**WEST SUSSEX COUNTY COUNCIL
INFRASTRUCTURE CONSULTATION**

SUBJECT: R/215/10

129 The Street, Rustington

Erection of signage

PROJECTING SIGN ELEVATION SCALE 1:20@A3

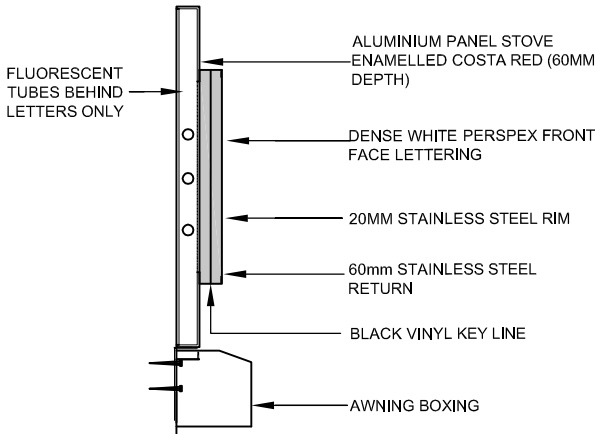
Before the commencement of any operation, the applicant is advised to contact West Sussex County Council (Tel no: 01243 642105) to obtain a Section 177 Licence under the Highways Act 1980 to cover any structure that overhangs the highway.
